PRELIMINARY PLAN HIGH VIEW ESTATES

A SUBDIVISION OF A PORTION OF THE NORTHWEST QUARTER
OF THE SOUTHEAST QUARTER OF SECTION 18,
TOWNSHIP 11 SOUTH, RANGE 65 WEST OF THE 6TH P.M.,
EL PASO COUNTY, COLORADO

PCD FILE No. MS222

PRELIMINARY PLAN HIGH VIEW ESTATES

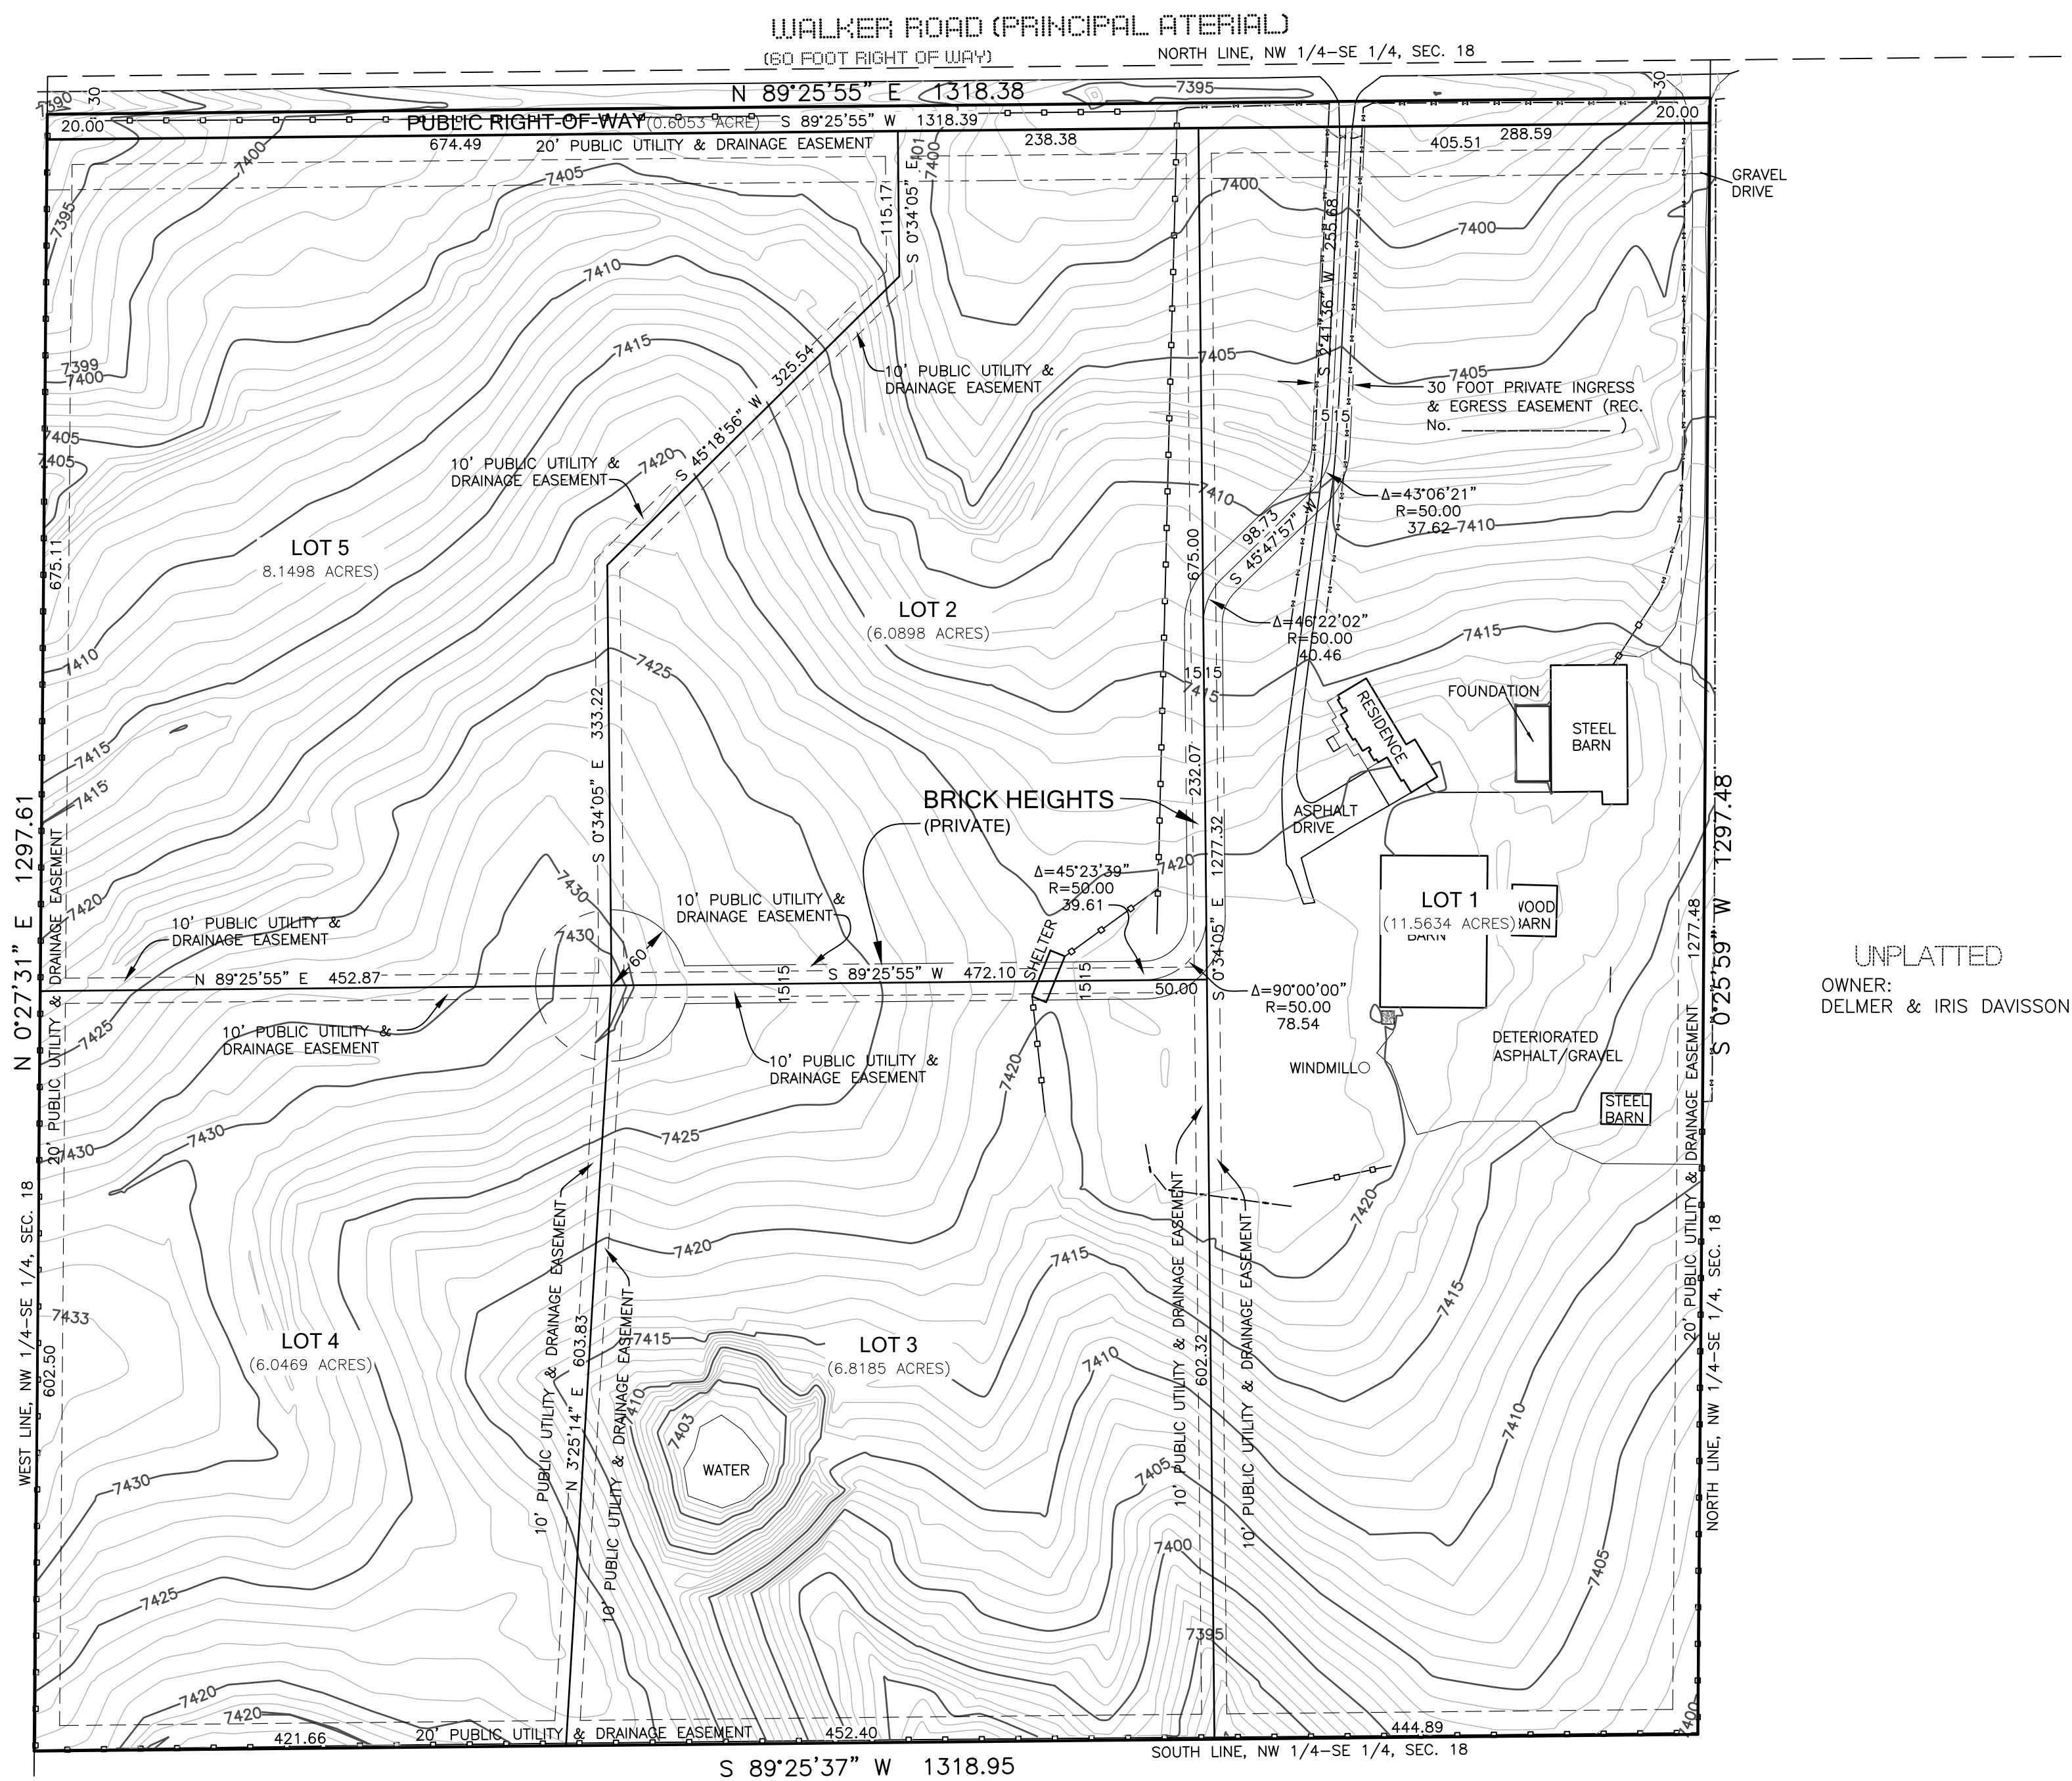
Revise access locations to be consistent with the traffic memo recommendations. Driveway locations appear to be in different configurations than what is recommended.

Change to minor arterial.

Please specifically note 50' ROW is being dedicated for Walker Road in this plat. Include a note in the general note section as well.

Provide notes for the preliminary plan that will be on the plat drawing.

Add the following notes to the preliminary notes:
